Highways Comments Response

APPLICATION NO: 2023/0165

DESCRIPTION: Erection of new two storey dwelling and associated double garage

LOCATION: Land to rear of 207 - 209 Manchester Road, Thurlstone, Sheffield, S36 9QS

drwg no & revision
ASK-JMA-ZZ-00-DR-A-(01)002D

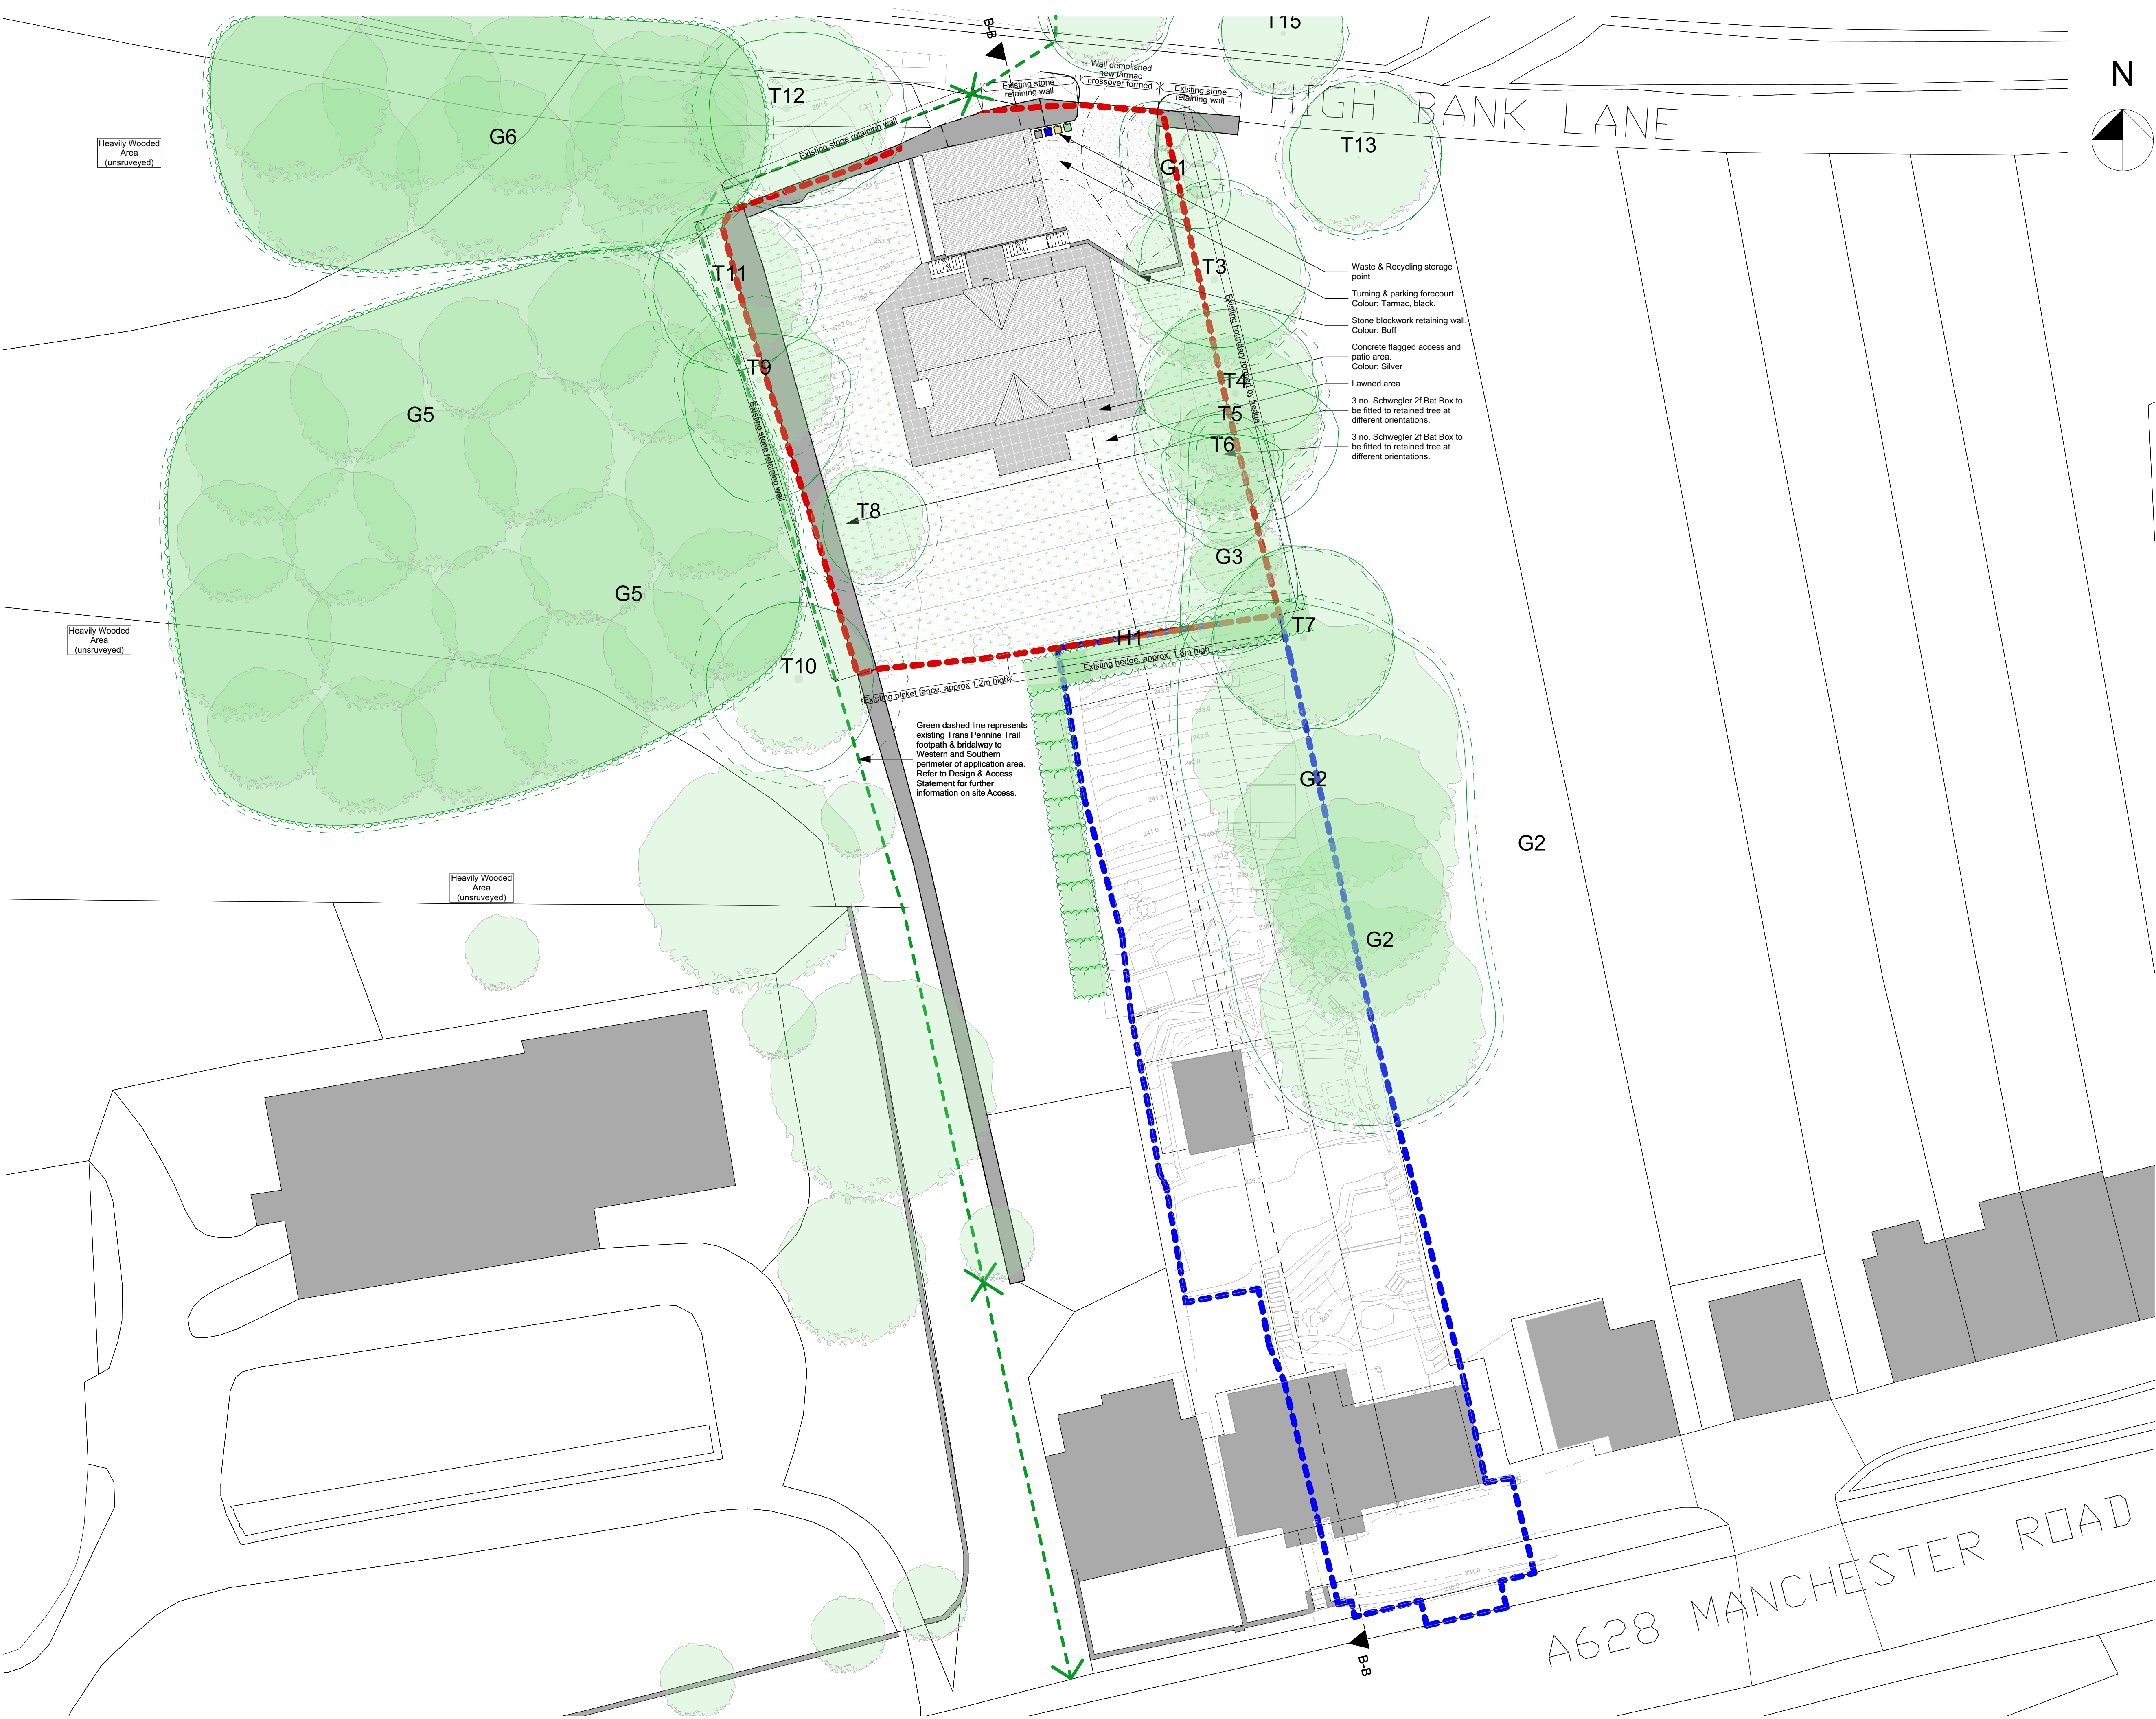
Although parking provision is now acceptable and refuse storage has been shown, visibility splays have not been submitted and a collection point for bins has not been shown.

- 3) Visibility splays – 43m visibility splays have been added to the part site plan produced, refer to ASK-JMA-ZZ-00-DR-A-(01)003A and a hand standing refuse collection point indicated immediately adjacent to the new proposed access, also updated on the proposed site plan ASK-JMA-ZZ-00-DR-A-(01)002E.
- 4) Safe & suitable access
 - a) Policy T3 stipulates new development will be... *“Be located and designed to reduce the need to travel, be accessible to public transport and meet the needs of pedestrians and cyclists;”*. The application site is within the urban boundary of Thurlstone and therefore has the benefit of being located within access to all the existing sustainable
